From: Amanda Scholes on behalf of Planning.Responses
Sent: 17 August 2017 08:54
To: Planning Scanning
Subject: FW: Planning Consultation on Y/52/17/DOC

APPLICATION NO: Y/52/17/DOC

Site Address: Longacre Maypole Lane Yapton BN18 0DR

Description of Works: Application for approval of details imposed under planning permission Y/5/16/PL relating to Condition 3 (Surface water drainage scheme), 4 (Landscaping scheme), 5 (Tree/root protection & 6 (materials of walls and roofs)

Services ID Plan
Scale 1:500

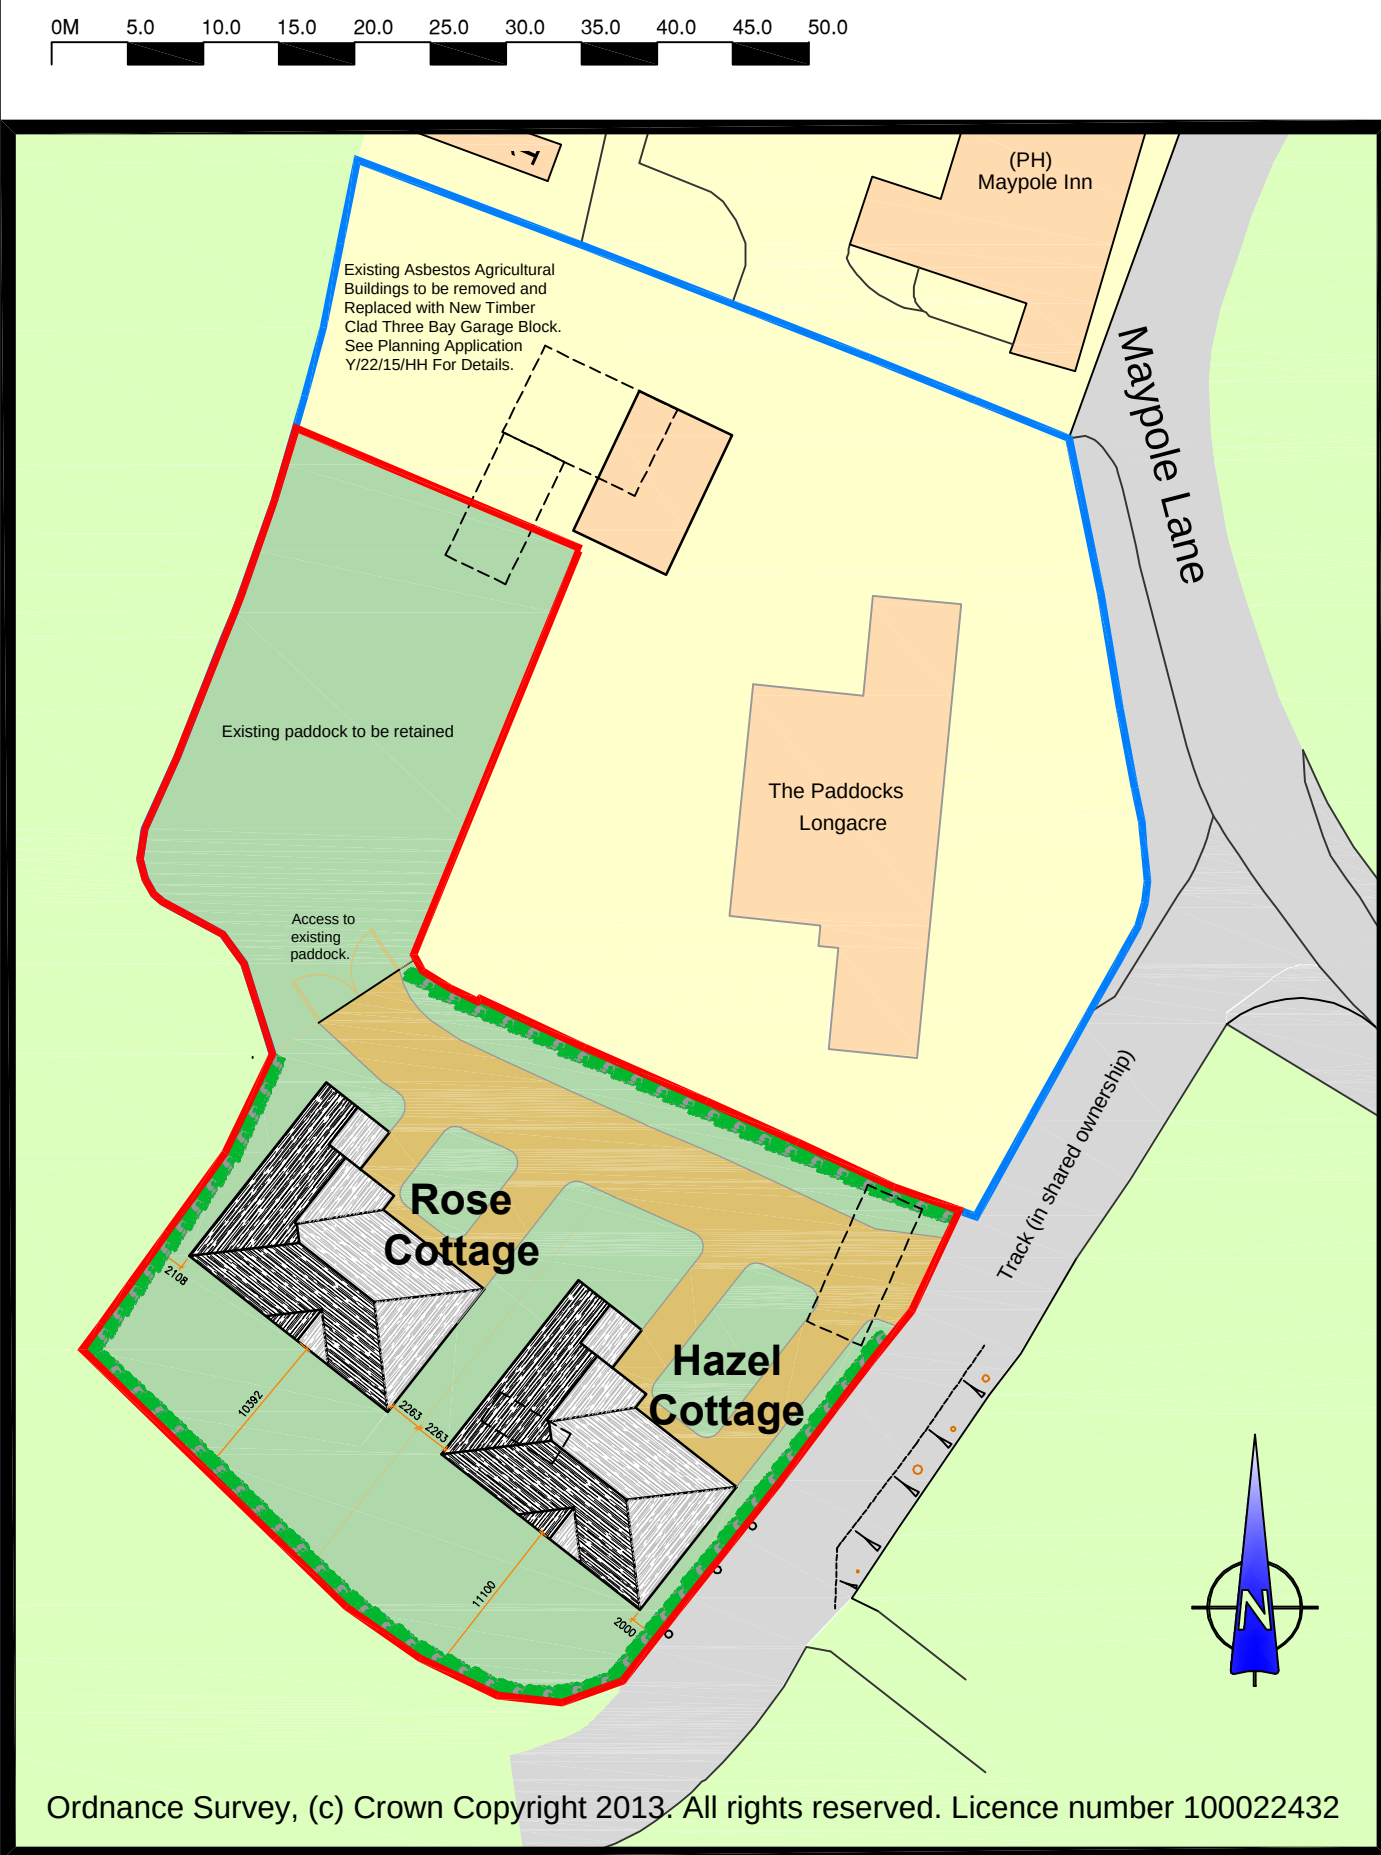
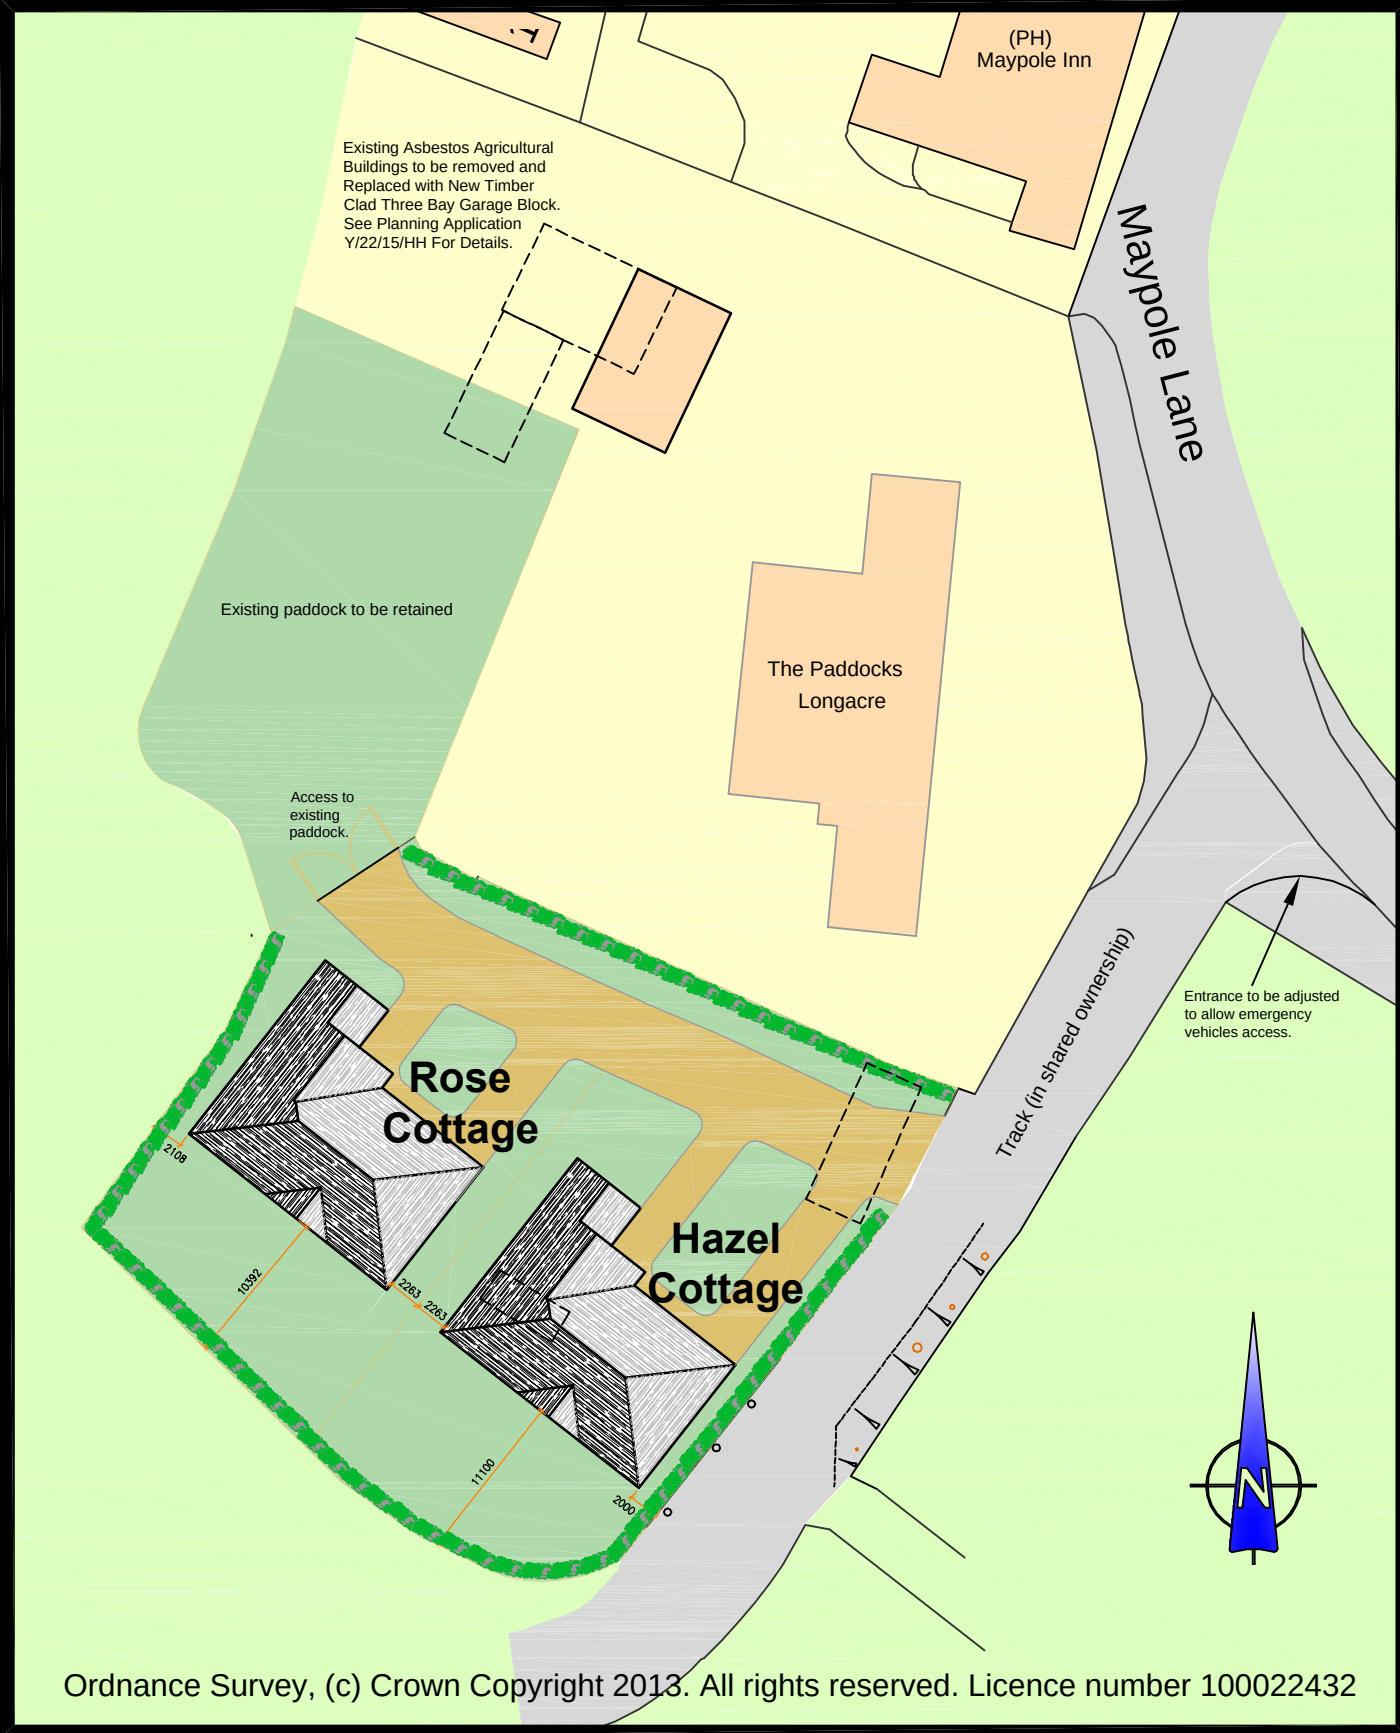
1. No winter groundwater monitoring data has been provided.
2. It is not known when the percolation testing was carried out, but it should be undertaken during the winter at an agreed depth, that is dictated by item 1. Full details of the test will be required and the infiltration rate must be calculated in accordance with BRE365.
3. Once items 1 and 2 have been established, the system can then be designed.
4. The system needs to be able to accommodate the 1 in 100 year storm event + climate change allowance.
5. Detailed drawings will ultimately be required showing the drainage proposals for both roof water and driveways/hardstandings. This will include all relevant levels, pipe diameters, gradients and construction details. The proposed rainwater harvestings systems will be beneficial and storage within them must be excluded from any storage calculations.

As a result of the points above and the fact that the proposals fall well short of what is required, I am currently unable to recommend discharge of the condition.
